Department of Transportation

SH83/Walker Rd
El Paso County

re: Monument Academy/YMCA_SH83Walker - Aug2019_Site Development Plan - EA18206_PPR199 -
REVISED for Hydraulic comments

PROPOSED DETENTION POND M3 PLAN

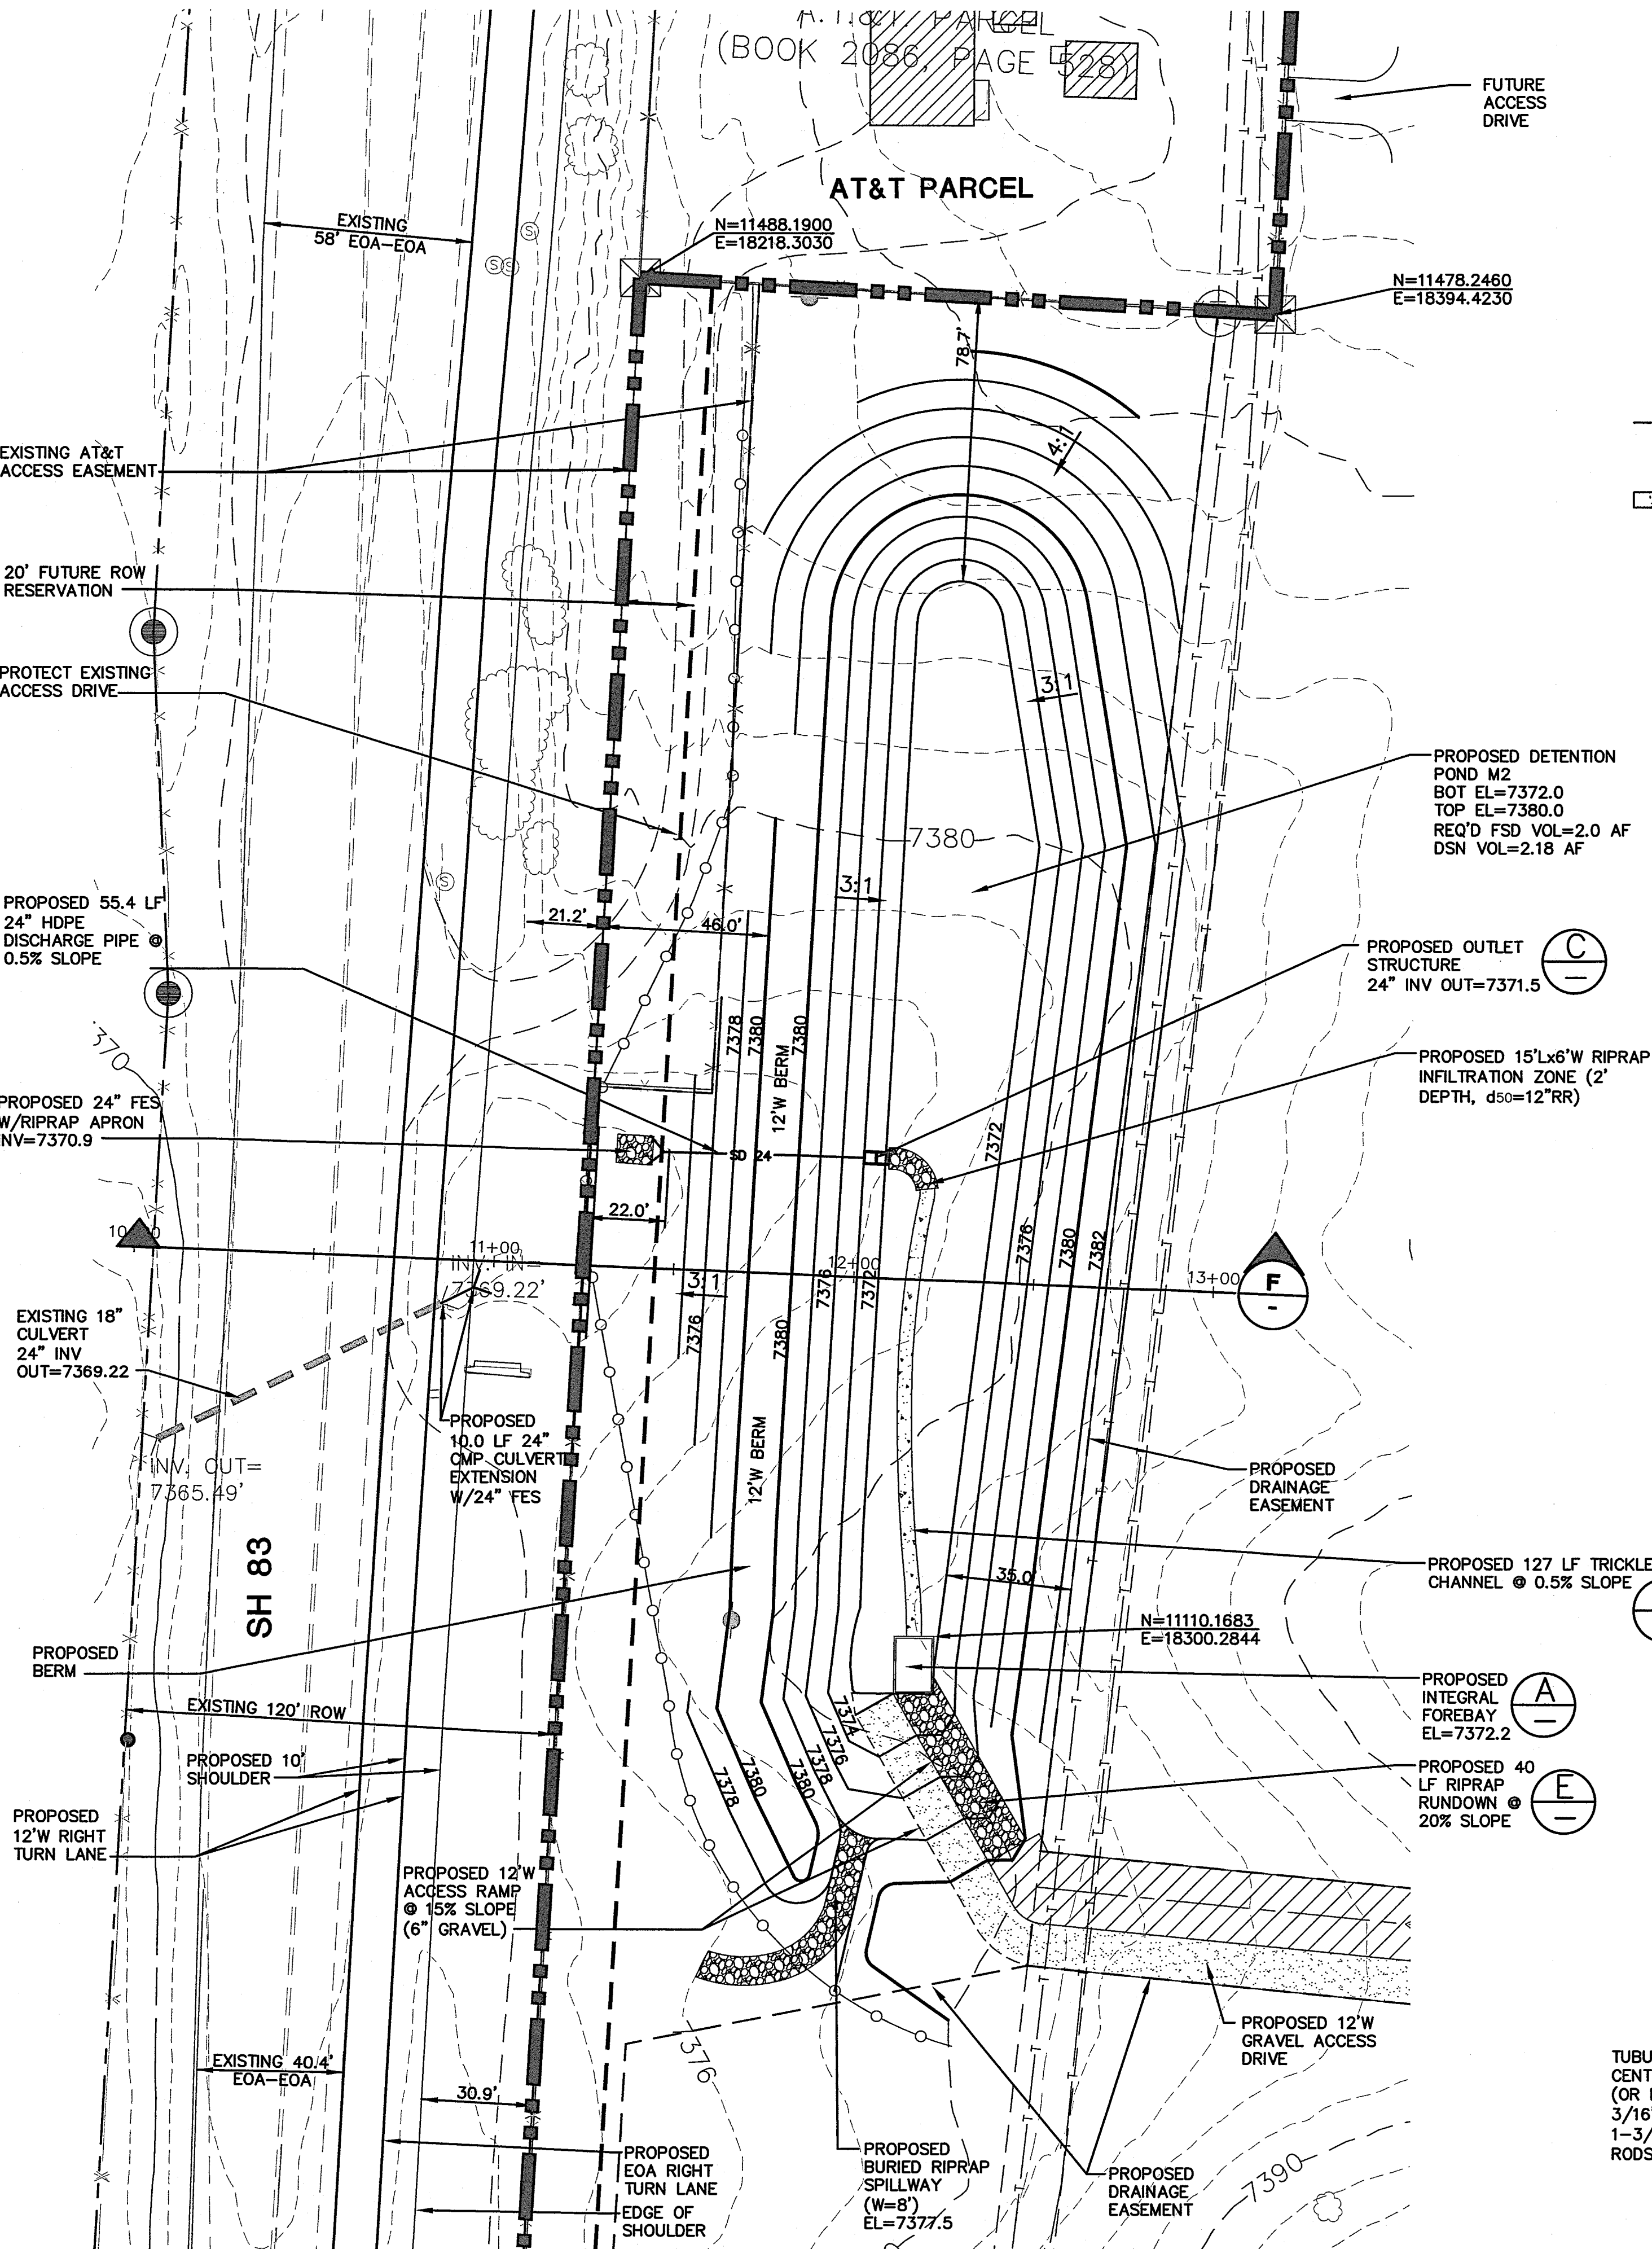
- d. Drainage Report/Grading Plan, Pond M3 - Pond spillway elevation given on pond sheet, but grading does not reflect spillway. At the height show, this pond exceeds 10' in height and could be classified as a jurisdictional dam. Please show grading of spillway to avoid this. Also, please provide detail of spillway and material used. Use of UDFCD spillway design guidance recommended. Not verified in the latest drainage submittal, please address and communicate back to CDOT.**

- f. Drainage Report, Forebay size required = .011 ac-ft., size provided in UD-BMP spreadsheet = 0.005, reviewer calculated = .007. Please increase forebay size to meet minimum required. Not verified in the latest drainage submittal, please address and communicate back to CDOT.**
